RE: WARNERVALE TOWN CENTRE

1. As requested, we have reviewed the operation of the proposed roundabout at the intersection Roads W05, W08 and the shopping centre access. The review addresses the matters raised by DPI as set out below:

Roundabout to Speed Ramp

TYPICAL ROAD CROSS SECTION  
ROAD W05

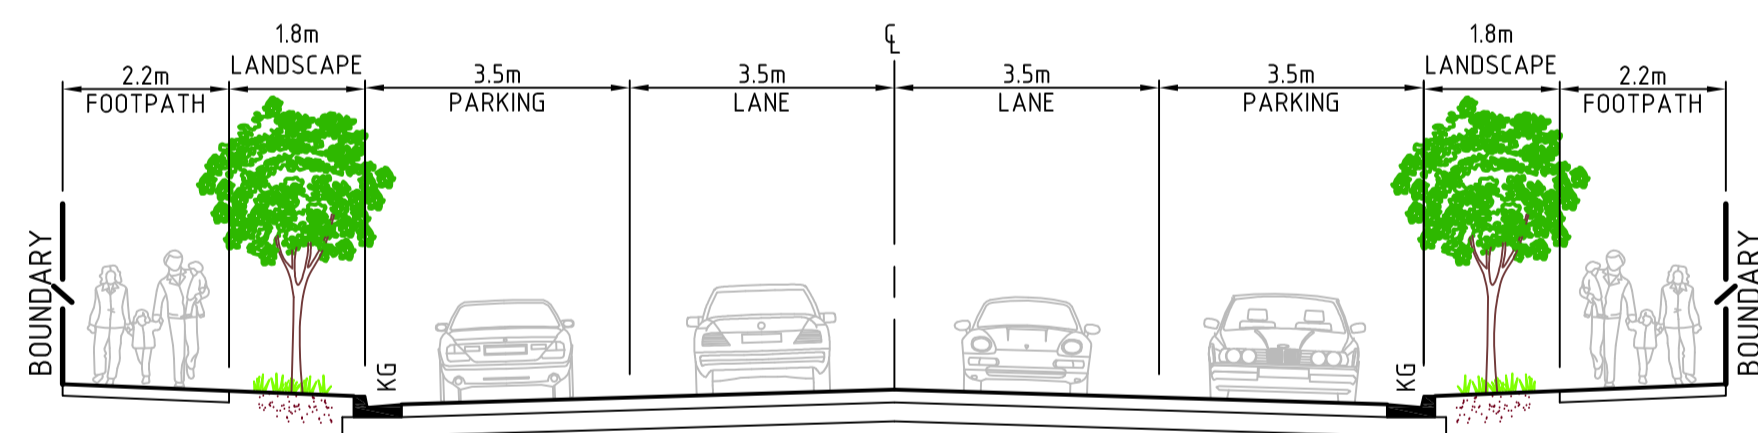
Further details should be provided to demonstrate that the roundabout at the intersection of roads W05 and W08 can function appropriately. This should include consideration of the speed ramp and peak period impacts such as queuing.

2. As part of the review of traffic matters raised by Council and RMS with respect to the Warnervale Town Centre road network, we have undertaken a SIDRA analysis of the operation of the roundabout in the Thursday afternoon peak period. Thursday afternoon is considered a peak period as the shopping centre would have a high level of traffic generation, combined with peak traffic flows on the surrounding road network. The SIDRA analysis found that:
 - the roundabout would operate with average delays of less than 15 seconds per vehicle (for all movements) in the Thursday afternoon peak period. This represents level of service A/B, a good level of intersection operation;
 - the maximum queue on the speed ramp to the roundabout was some 30 metres. A queue of 30 metres would not affect traffic flow on the speed

ramp. Maximum queue length on the other approaches to the roundabout was less at some 7 to 26 metres.

3. Thus in summary the proposed roundabout at the intersection Roads W05, W08 and the shopping centre access would operate at good level of service in the Thursday afternoon peak period with minimal queuing.
4. We trust the above provides the information you require. Finally, if you should have any queries, please do not hesitate to contact us.
